Office of
Environment
& Heritage

DOC16/507690-9

Amended development application for Crookwell 3 Wind Farm SSD 6695

ALLISON TREWEEK 14/11/16
Senior Team Leader, Planning - South East
Regional Operations Group
OFFICE OF ENVIRONMENT AND HERITAGE

Figure 2 | Project Layout

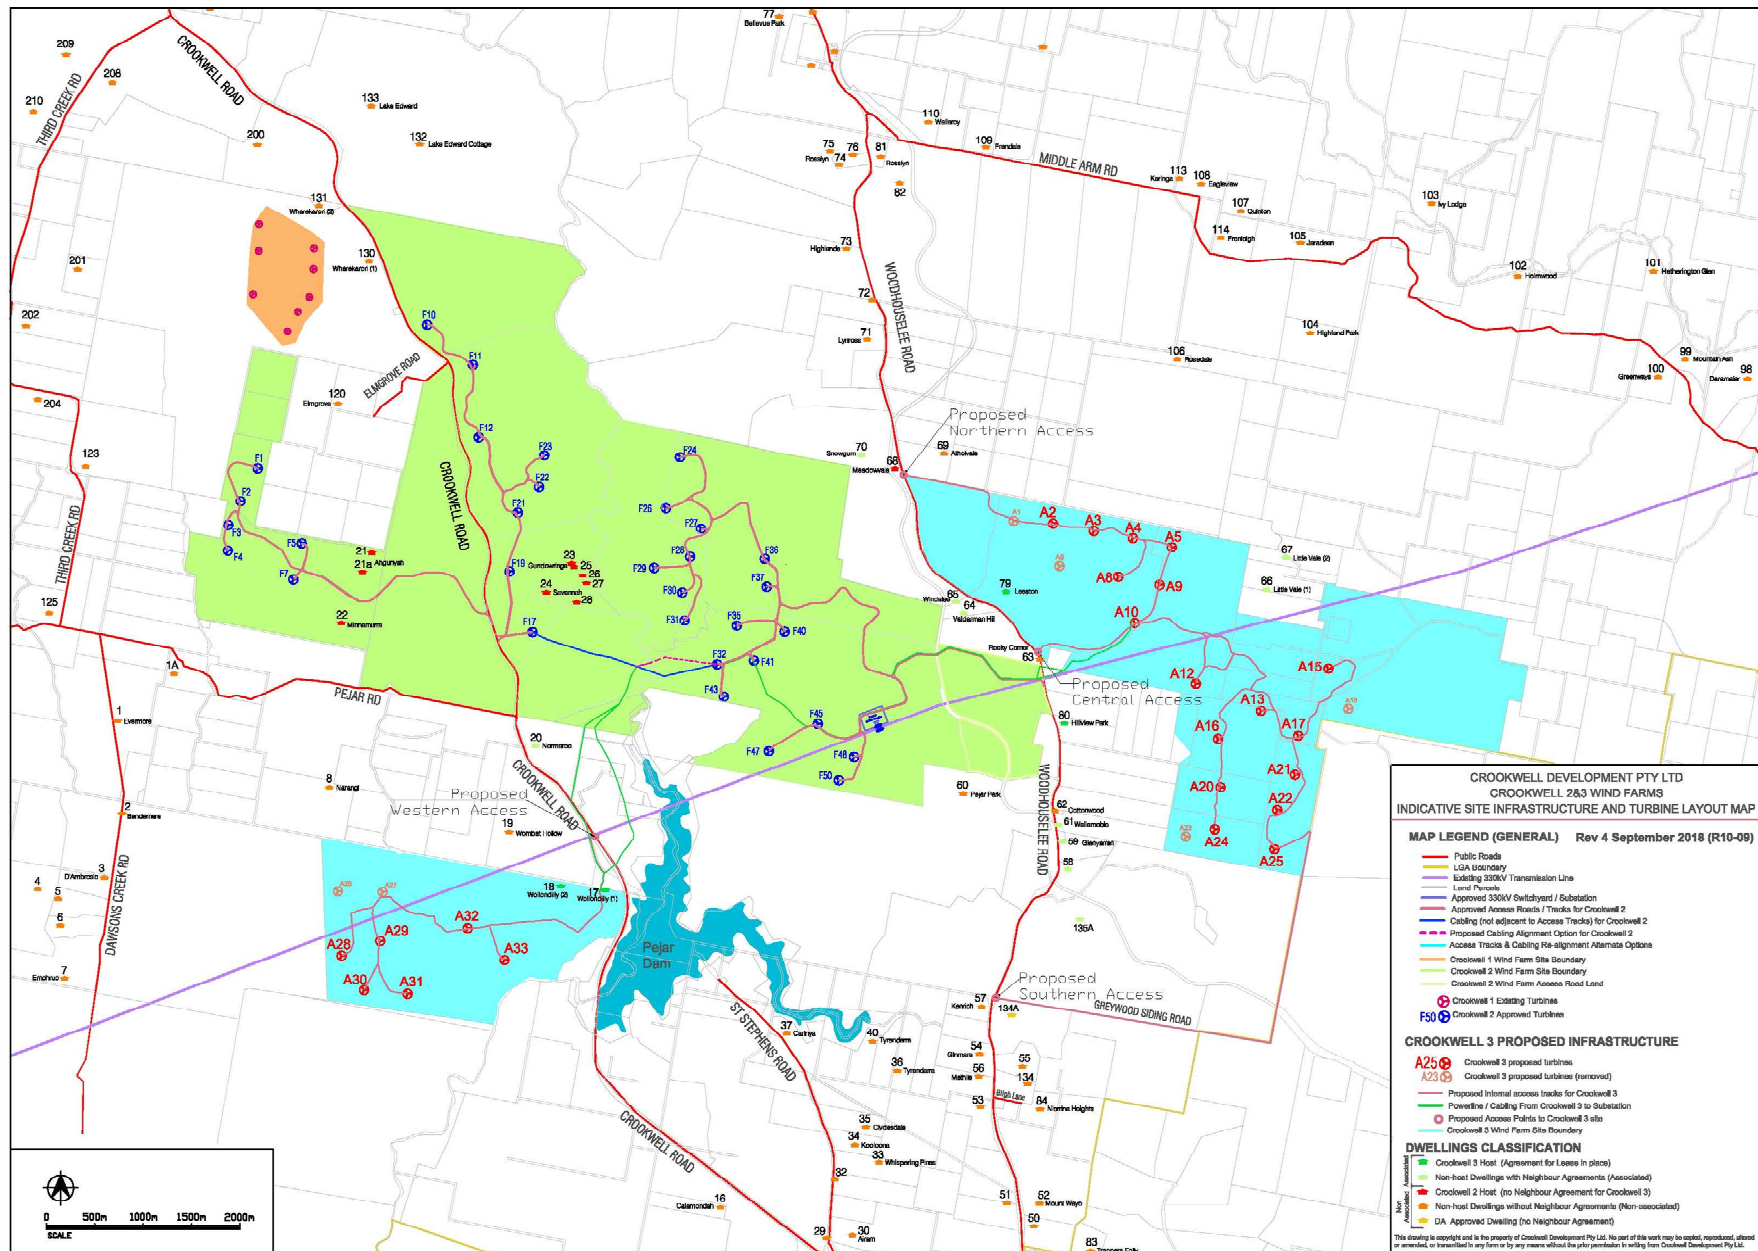
Matter	OEH comment
Access track realignments	There has been a minor change to the alignment of access track between turbine A13 and A16 to avoid the box gum woodland. However the layout in Figures 2 and 3 in the Addendum Environmental Impact Statement doesn't look any different. These figures should be updated to show these changes.
Turbine A24 realignment	The Ecology report states that there has been a slight change of location for turbine A24, however it doesn't look any different between Figure 2 and Figure 3 in the Addendum Environmental Impact Statement. These figures should be updated to show these changes.
Turbine A26 and A27 removal and track realignment	OEH notes and supports the removal of turbine A26 and A27 from within the Box Gum derived native grassland path in the western part of the project area and the realignment of the access track to avoid this patch. However it doesn't appear that the realignment to the access track is reflected in Figure 3 – Proposed Infrastructure layout. This should be updated to reflect the changes.
